APPLICATION NO: 20/01011/FUL/ADDINF

DESCRIPTION: Single storey rear extension of boiler room to provide 2no single occupancy assisted living units with care worker facilities and communal meeting area and alterations

LOCATION: Calcott Rectory Close Bracknell

PROPOSED PLAN 1:50

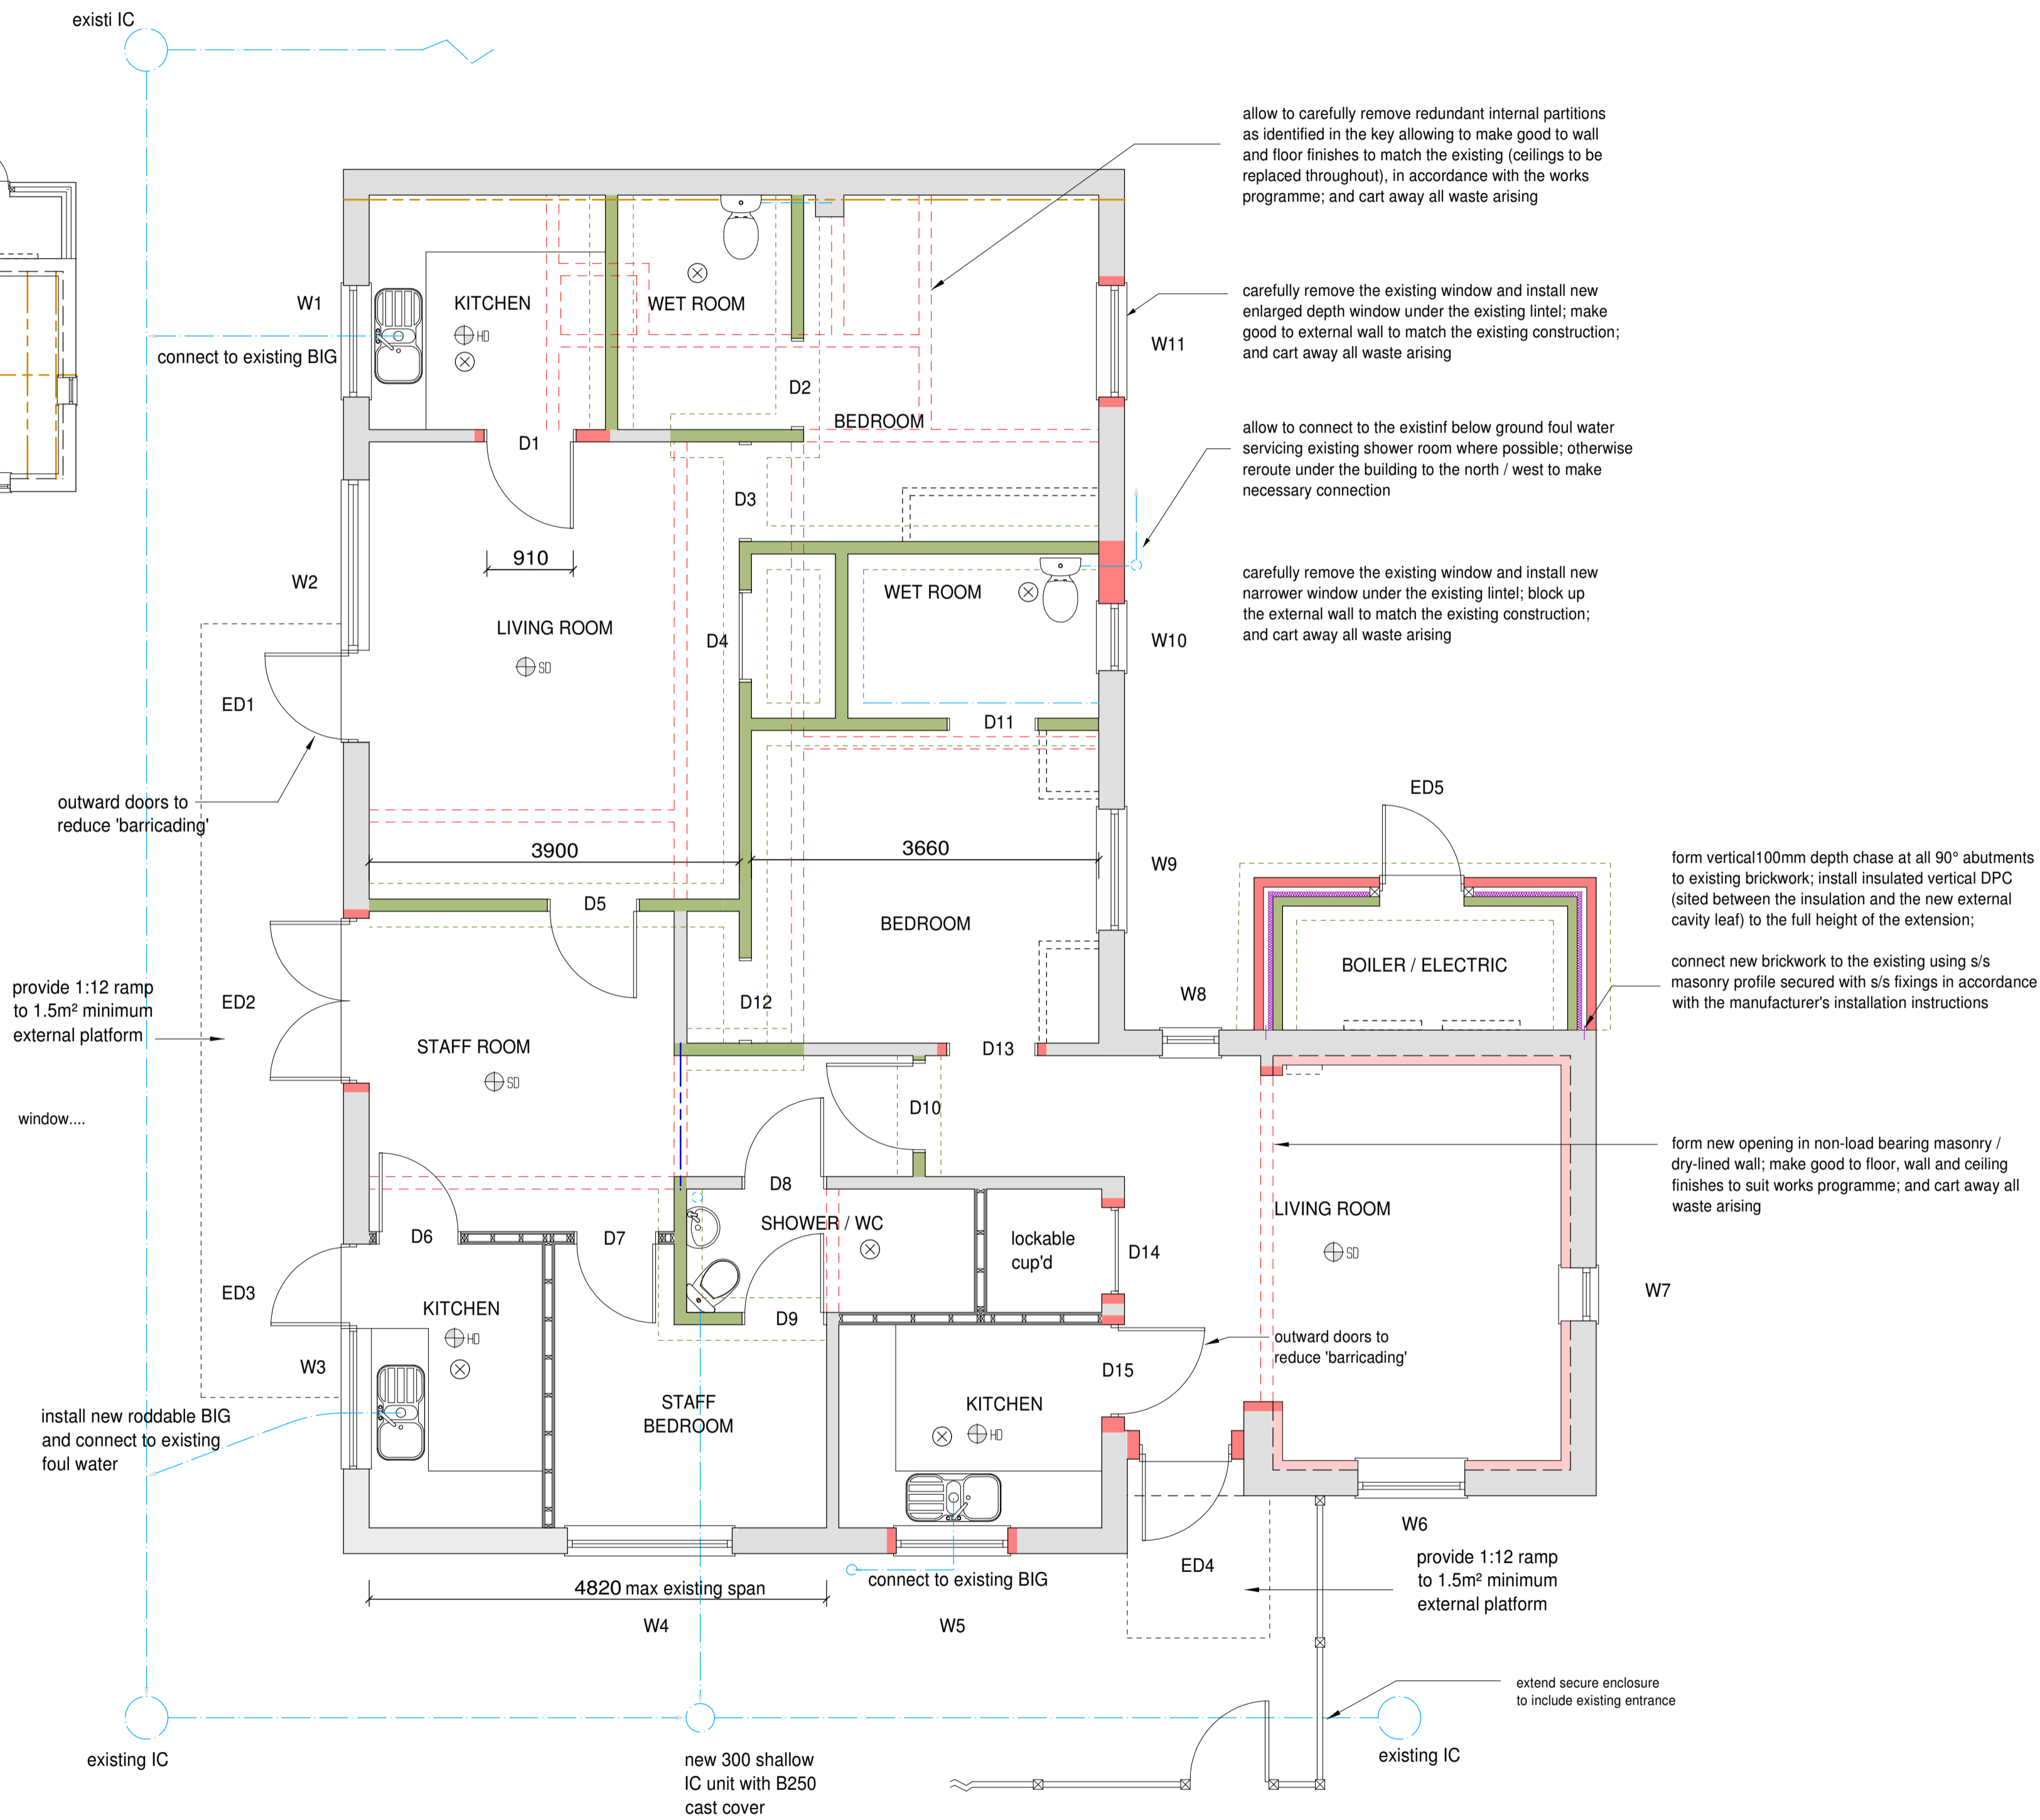
- 1 There are double doors shown on the floor plan that do not appear on the North Elevations. Please could you amend accordingly.
- 2 To date we have not received a fee of £234. which is required for this application. This payment can be made over the phone to our customer services team on 01344 352 000. Please quote your application number when making payment.
